RESPONSE LETTER TO PLAT RE-SUBMITTAL

KITITAS COUNTY **DEPARTMENT OF PUBLIC WORKS**

MEMORANDUM

SUBJECT: Forest Ridge Final Plat Resubmittal LPF-20-00005

DWN BY T.S.	DATE 01/2021	JOB NO. 18069
CHKD BY M.K.K./D.L.P.	SCALE 1" = 100'	SHEET 4 OF 6

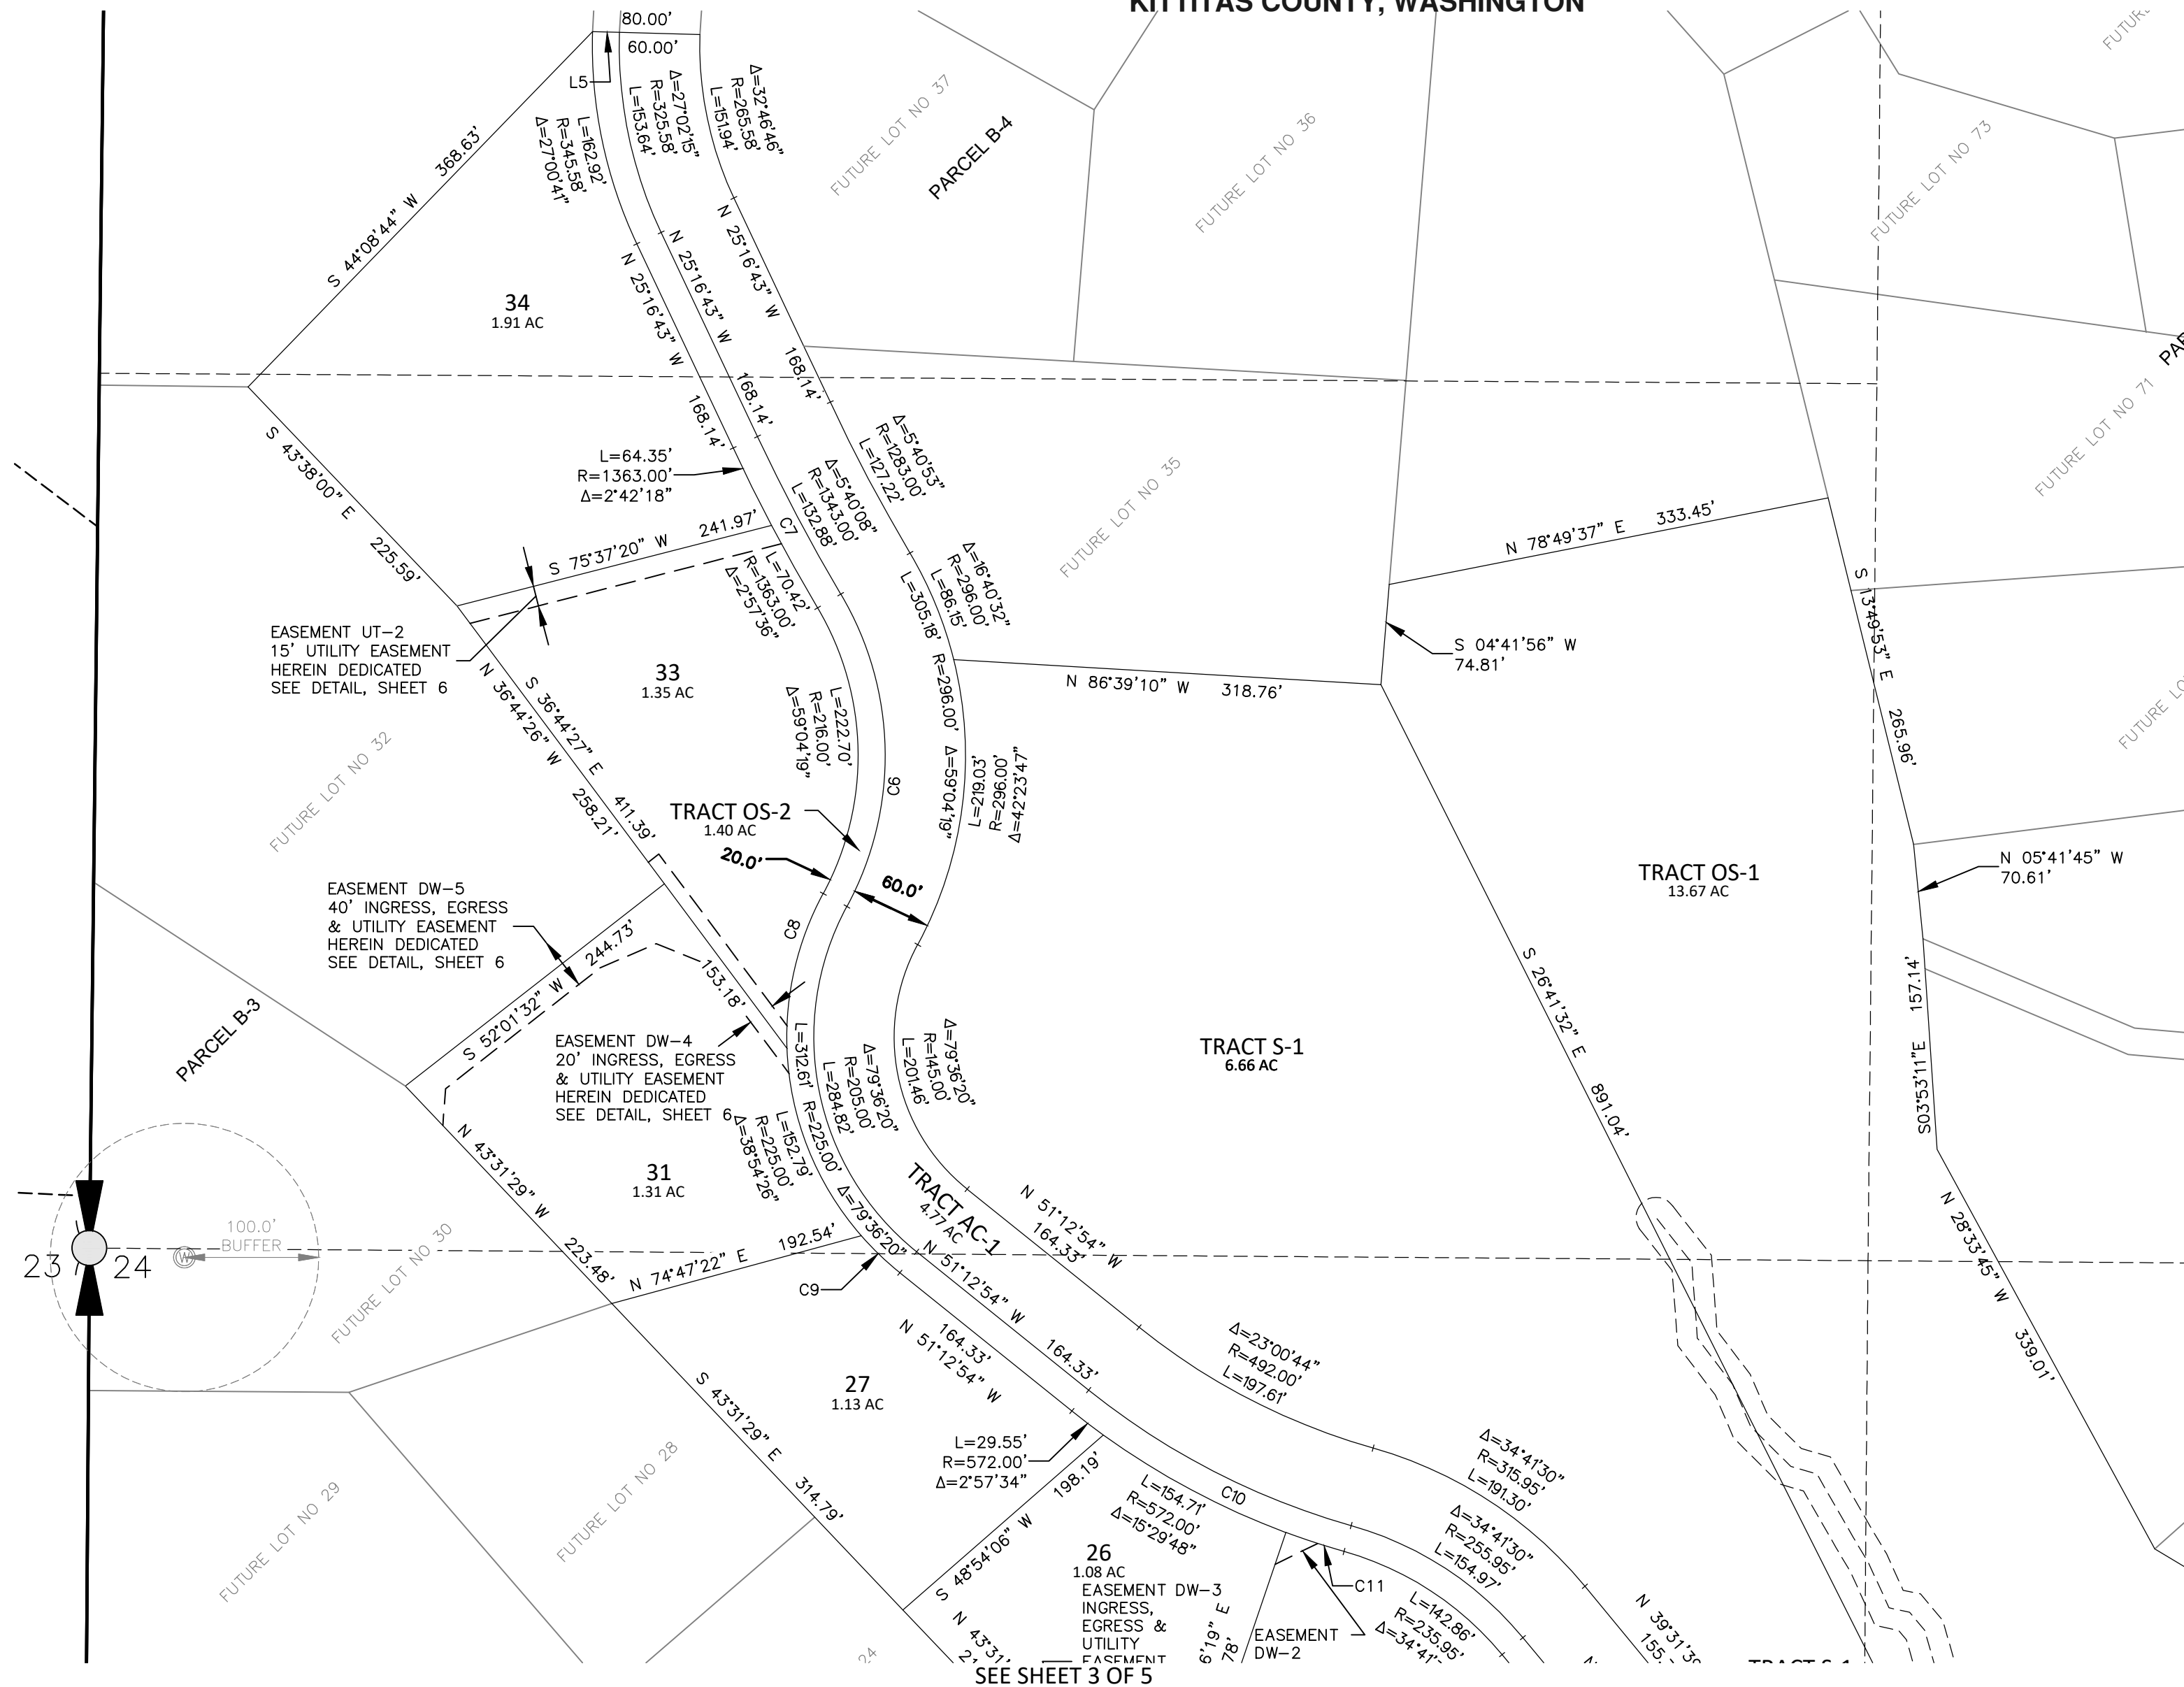
12. The East Boundary of AC-1, adjacent to Future Lot 37 does not match the closure report.
13. The North Line of the Easement DW-5 appears to have missing linework. It is also discrepant between page 6 and page 4.

SEE REVISED PLAT MAPS AND CLOSURES FOR ALL CHANGES REQUESTED BELOW.

FOREST RIDGE - PHASE I PERFORMANCE BASED CLUSTER PLAT		
PREPARED FOR FRPP PHASE I, LLC A PORTION OF SECTION 24, TOWNSHIP 20 NORTH, RANGE 15 EAST, W.M.		
KITITAS COUNTY		WASHINGTON
DWN BY T.S.	DATE 01/2021	JOB NO. 18069
CHKD BY M.K.K./D.L.P.	SCALE 1" = 100'	SHEET 5 OF 6

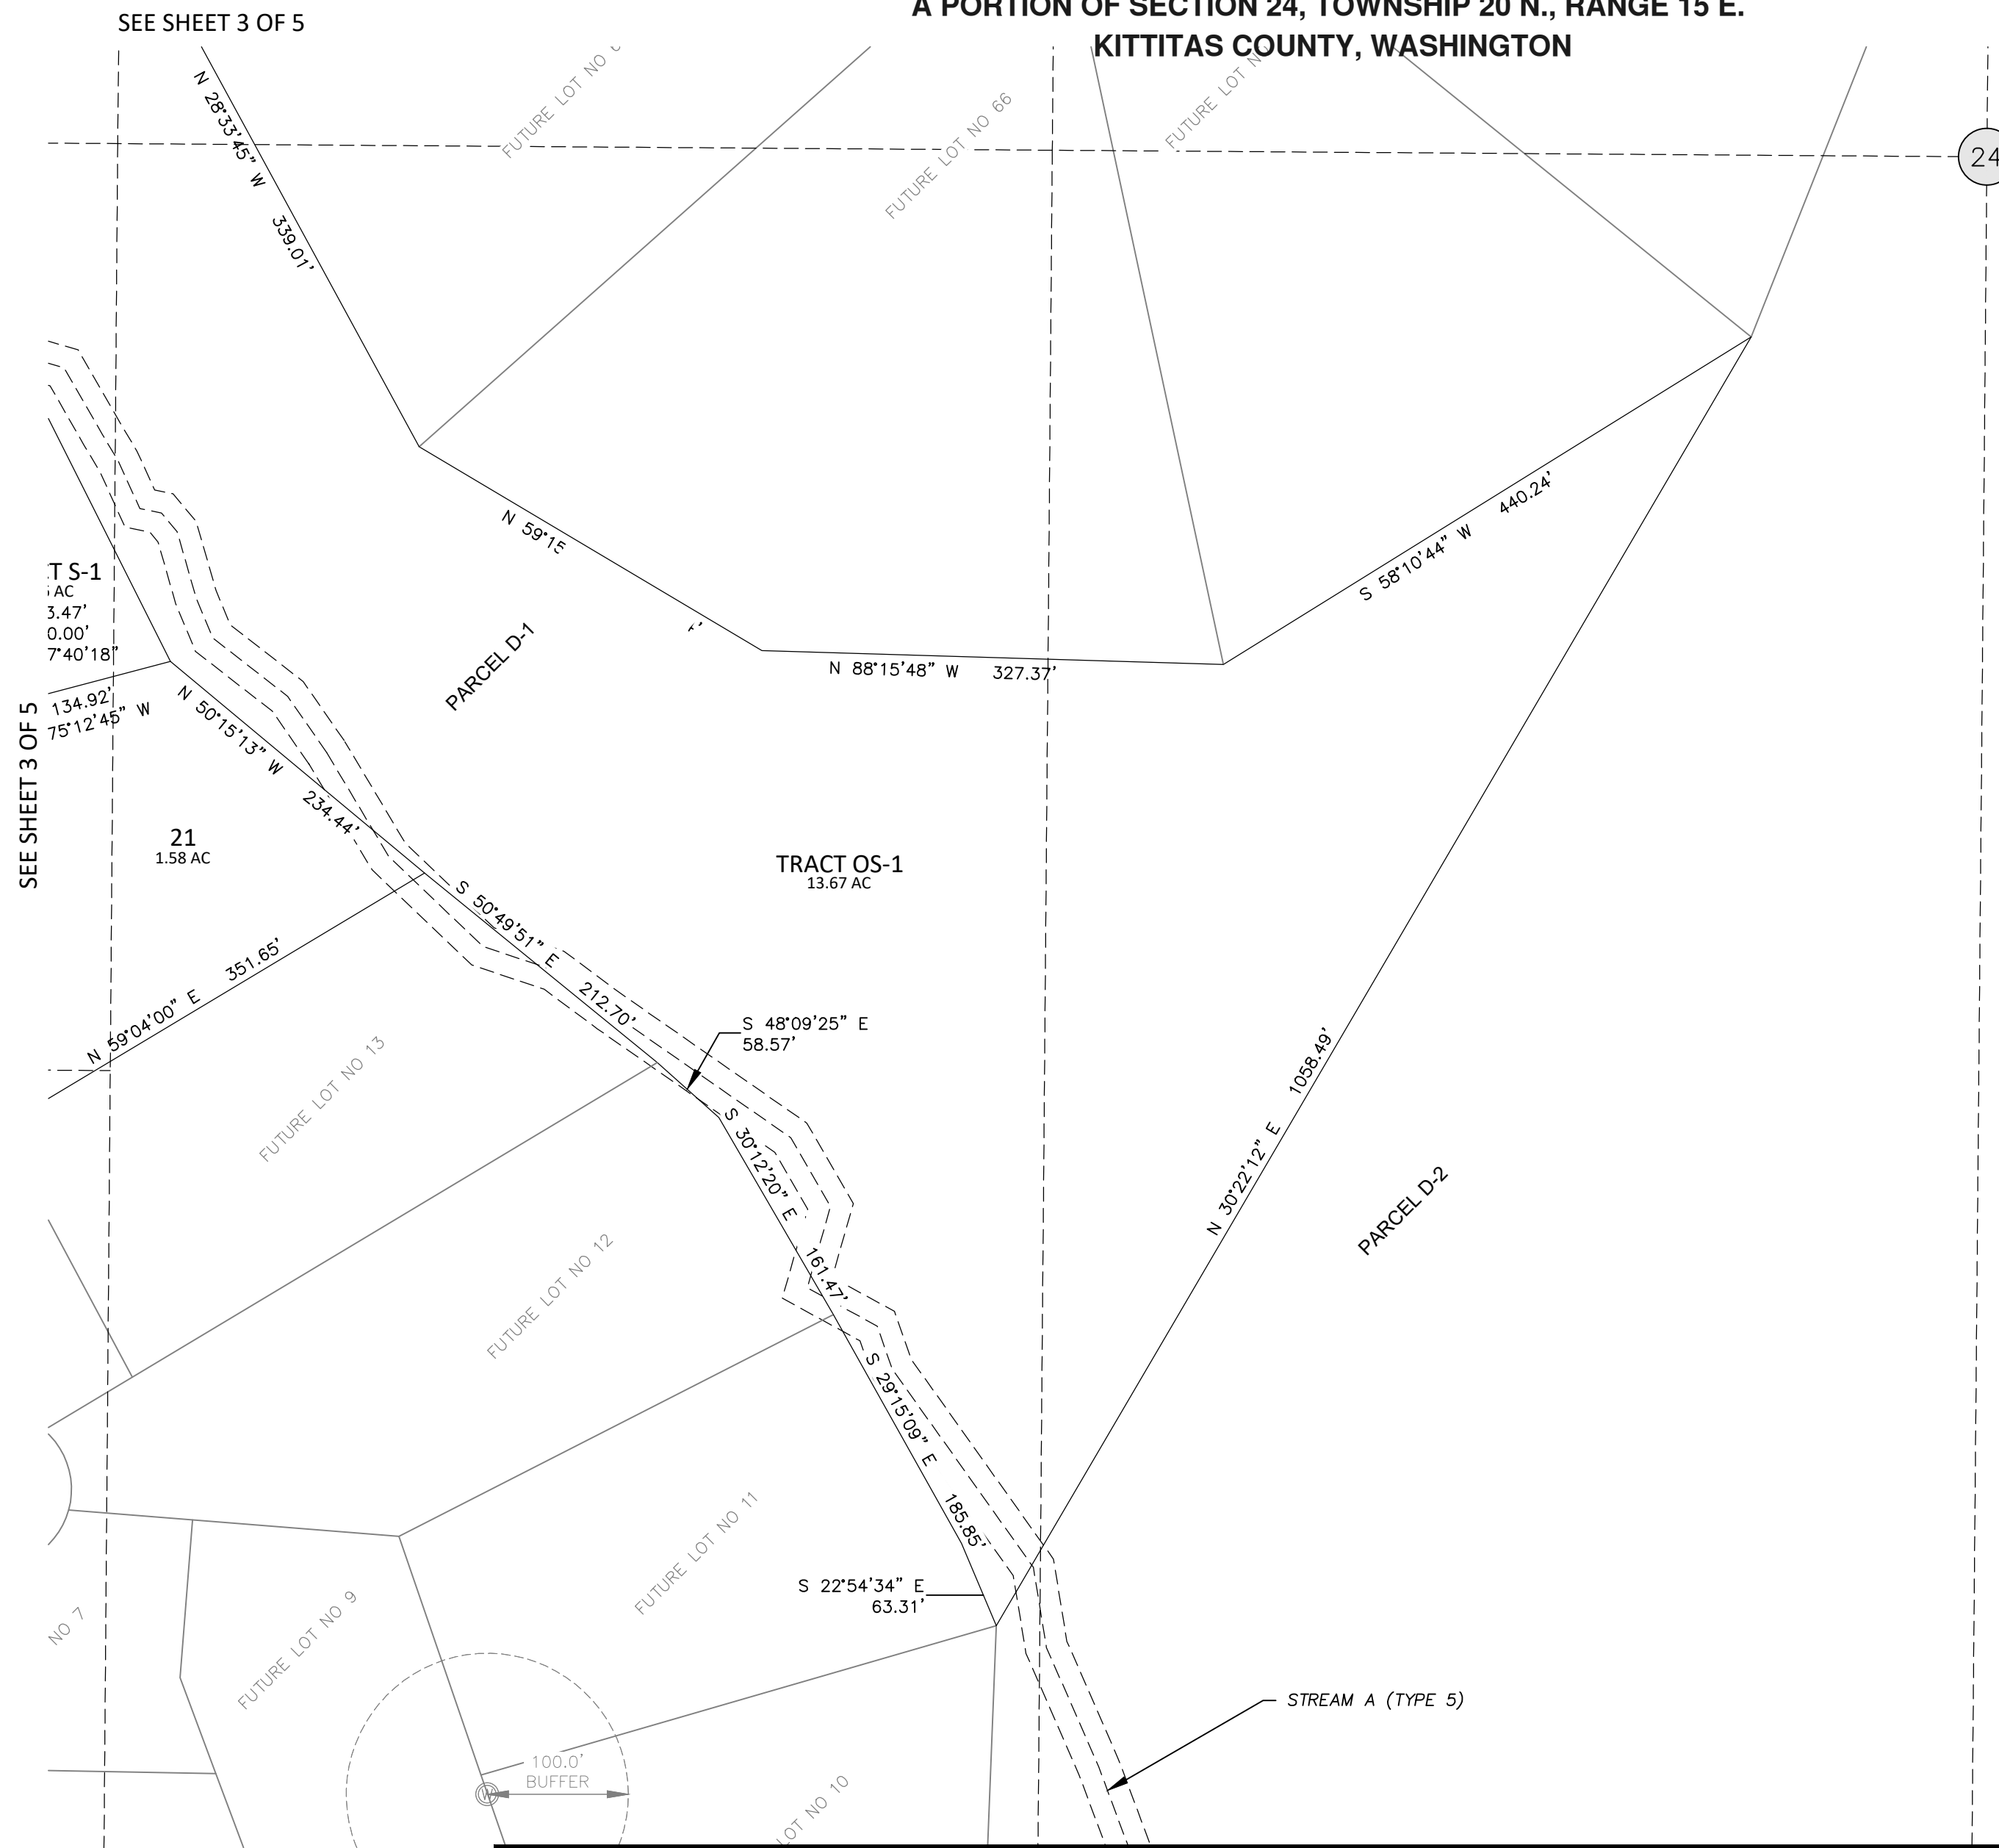
1. Survey Note 3, Sheet 1 shows a blank for the equipment used, and includes a few typos.
2. The N1/4 corner and the E1/4 corner do not have ties to determine the location.
3. Section corners are shown in the legend "as noted". Map contains no such notation.
4. The parcels identified as FD-2, FD-3 and FD-4 do not have any defined limits shown.
5. The historic parcels A-1 through D-2 can be confusing as they are not clearly identified as historic parcels. Including the recording number (AFN or Book and Page) would clarify this.
6. Set corners shall be shown on the face of the plat.
7. References to other pages (See Sheet X of X) are incorrect in the total page count, (all occurrences) as well as the reference page (n[']most label, sheet 5)
8. There are multiple occurrences of labels being obscured by crossing linework.
